Subject: RE: Planning Consultation on Y/23/20/DOC

Engineers Comments Regarding Surface Water Drainage

APPLICATION NO: Y/23/20/DOC

Description of Works: Approval of details reserved by condition imposed under ref Y/70/19/HH relating to Condition No 3 - surface water drainage scheme

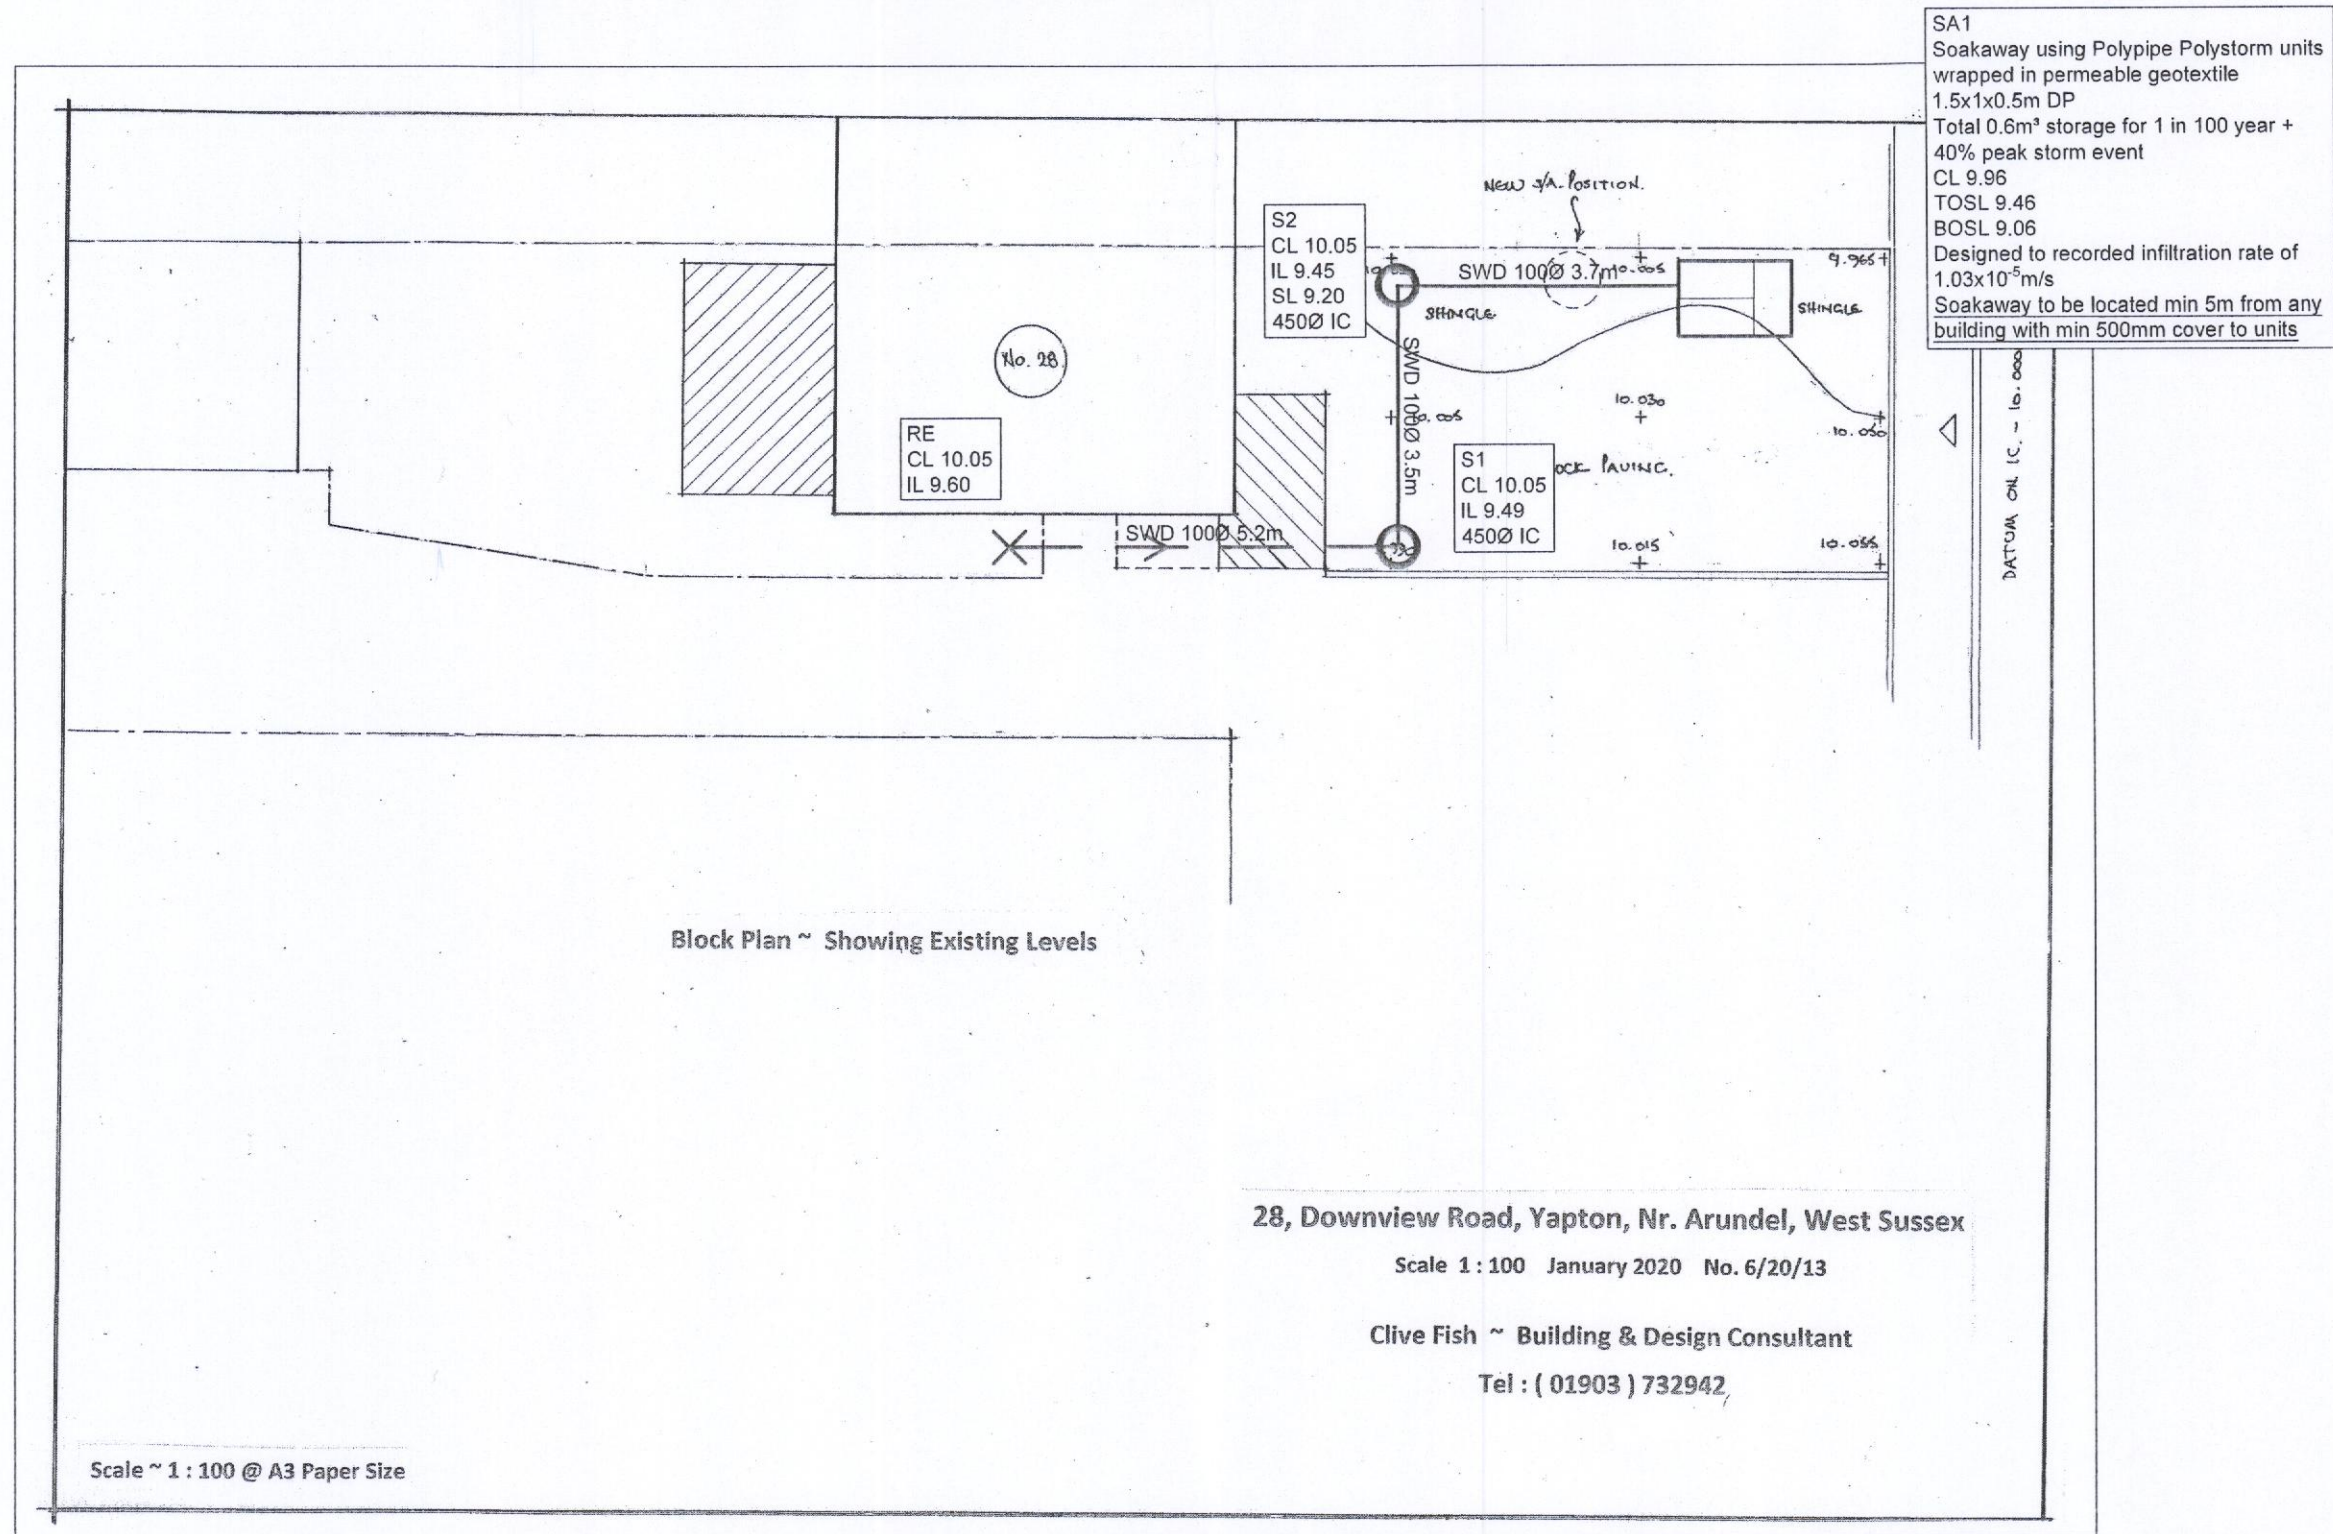
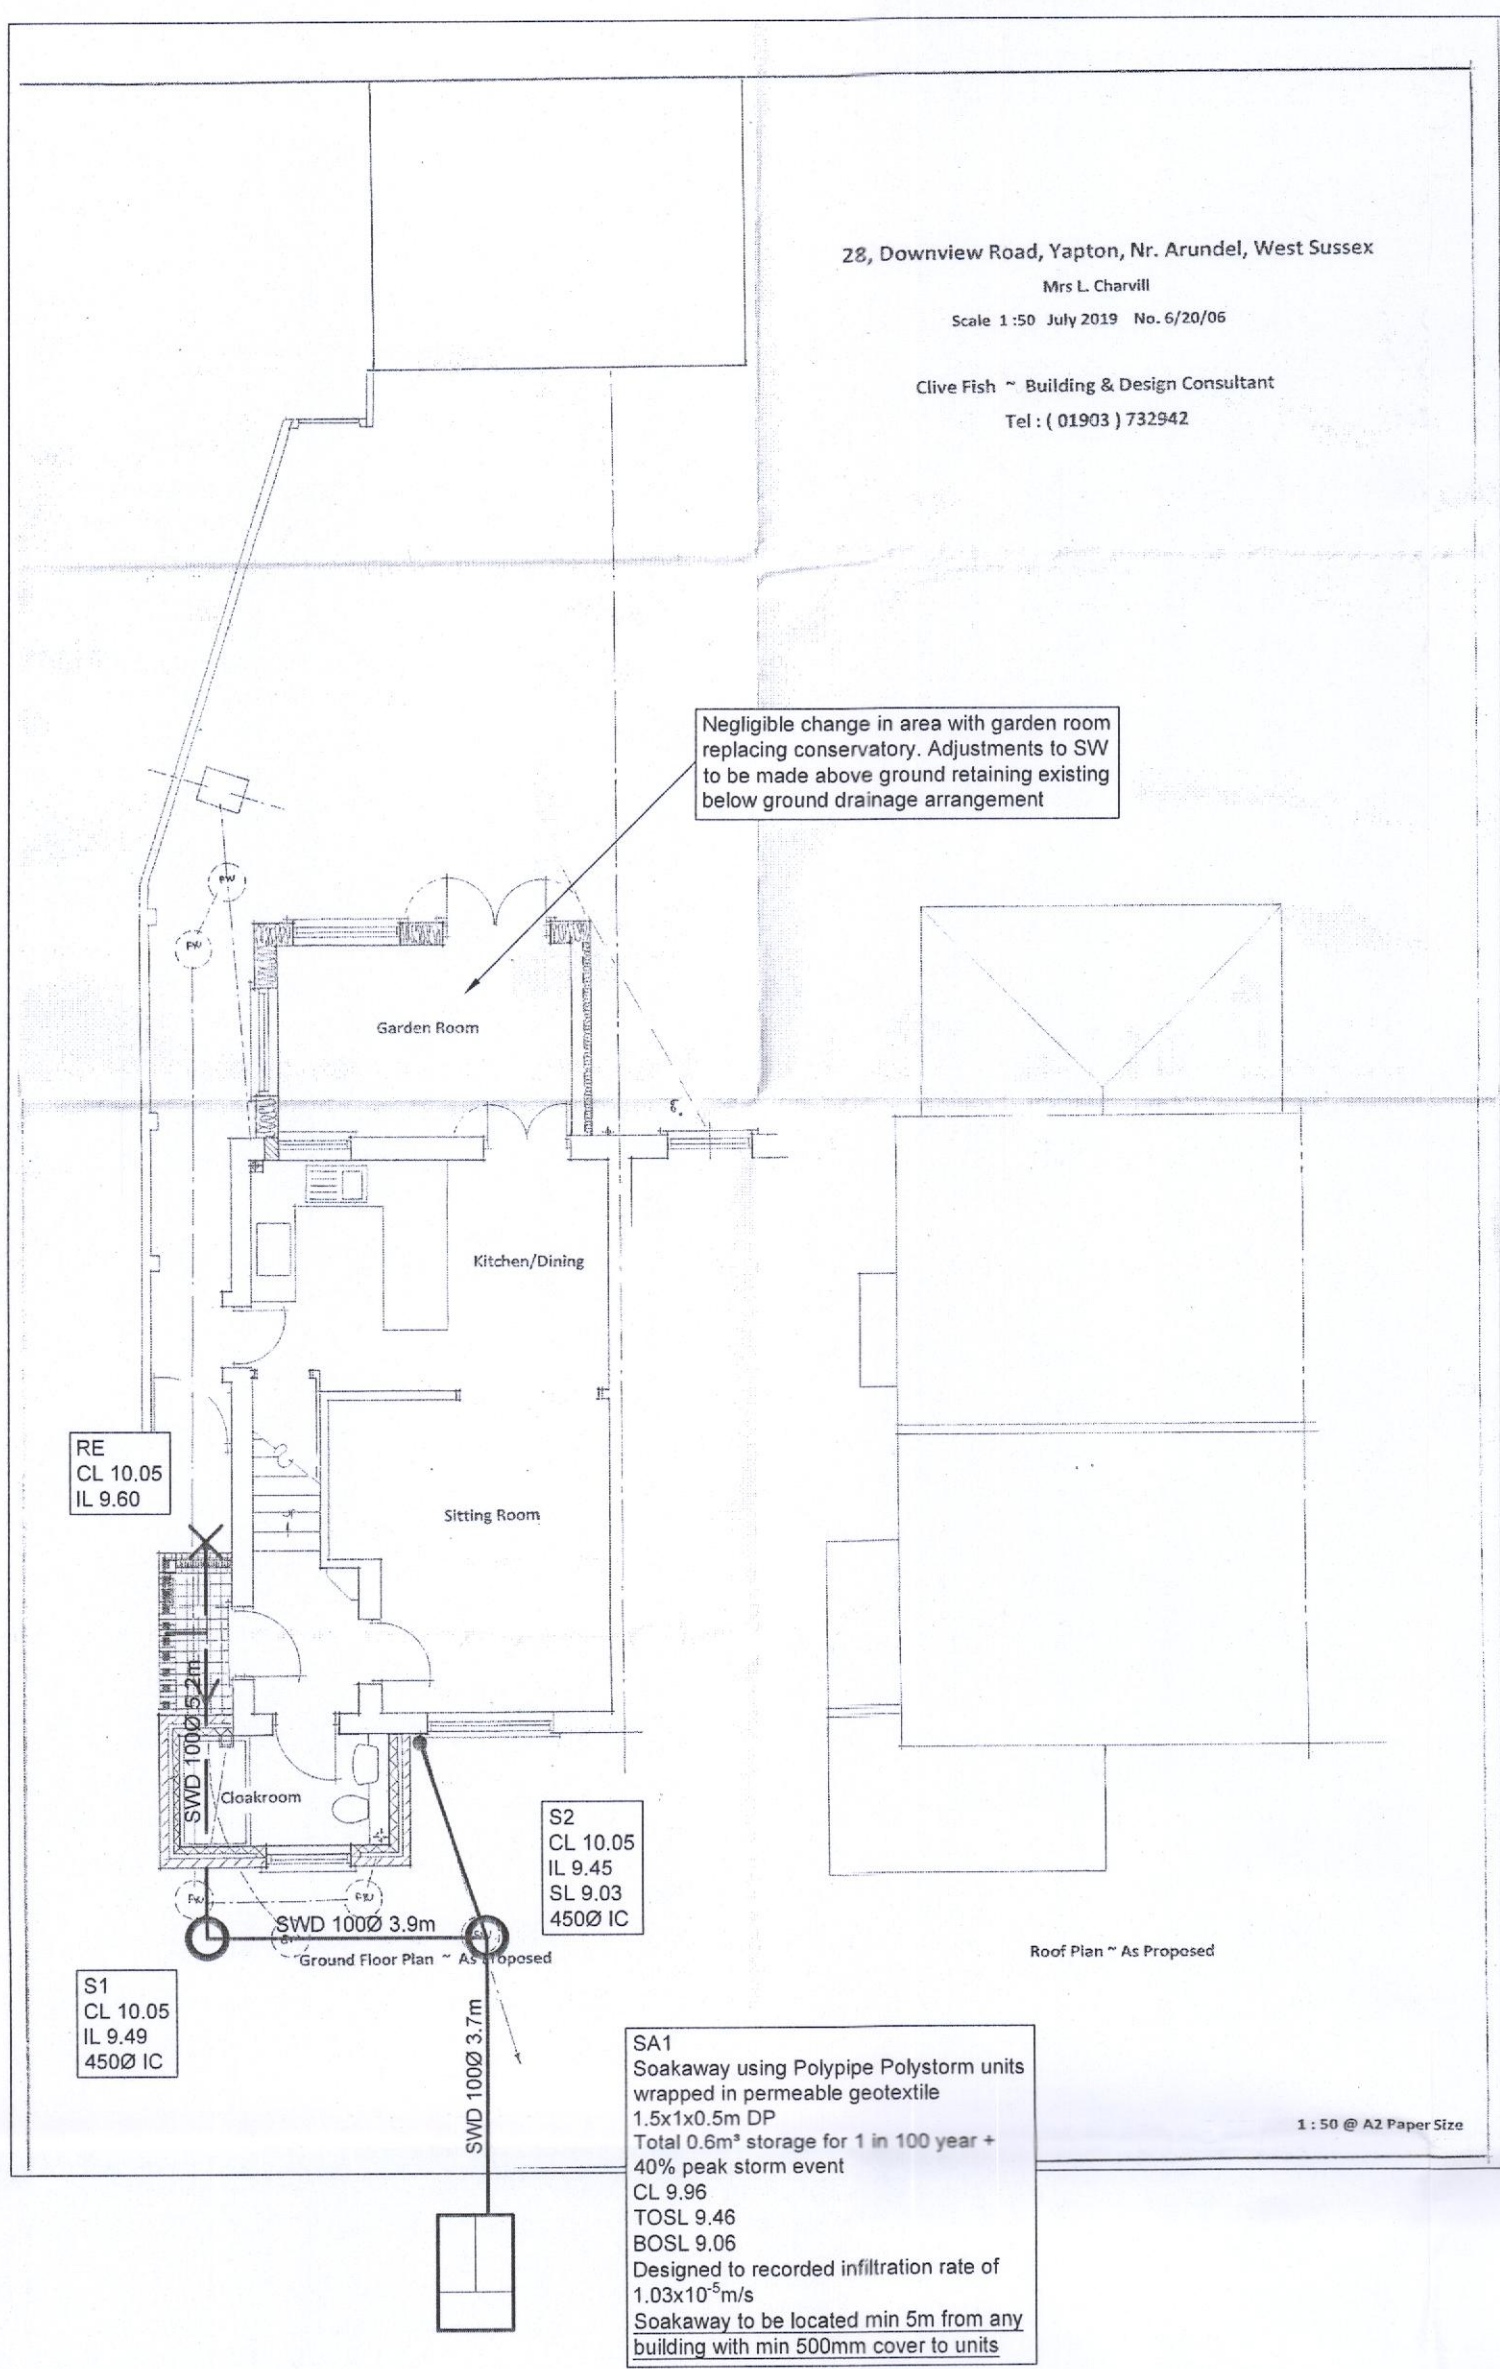
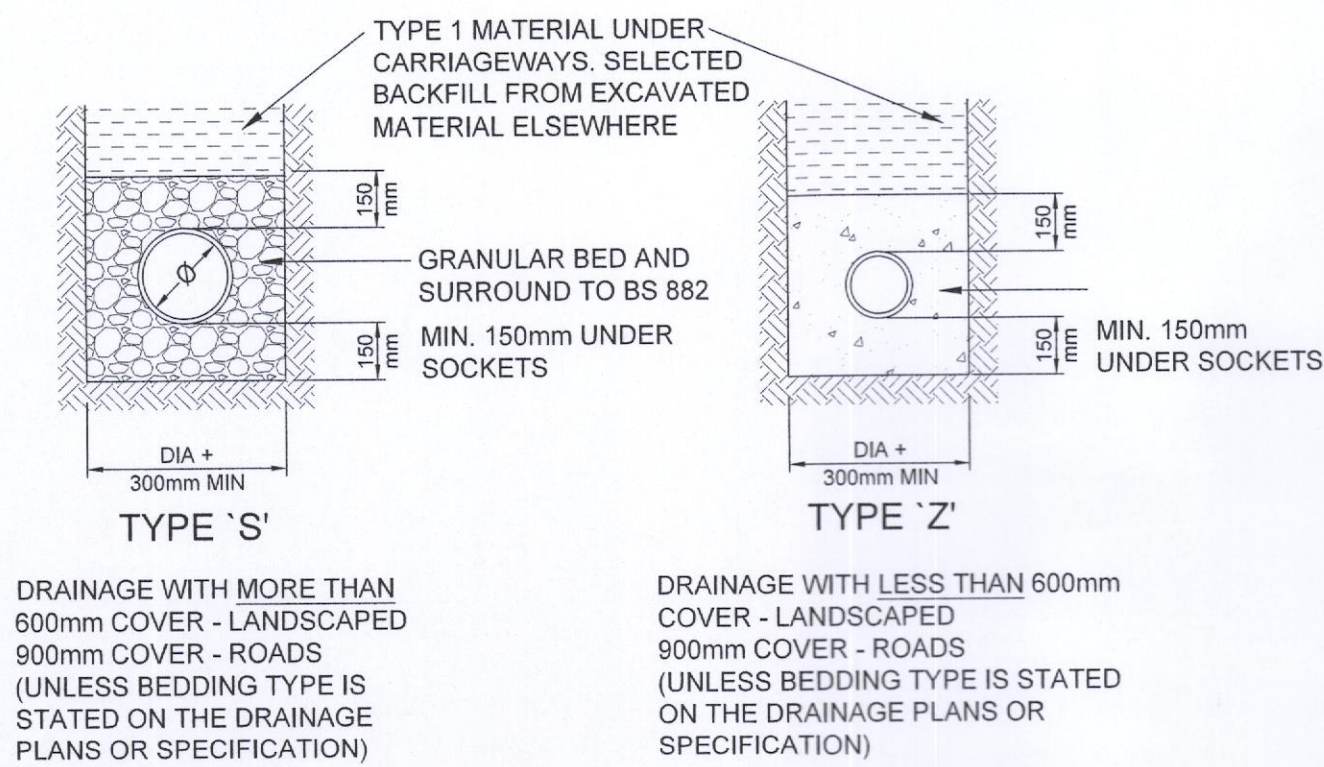
The plans lack a note to state the pipe materials (when not adopted), however, it is trusted that this can be added by the applicant before issue to a contractor.
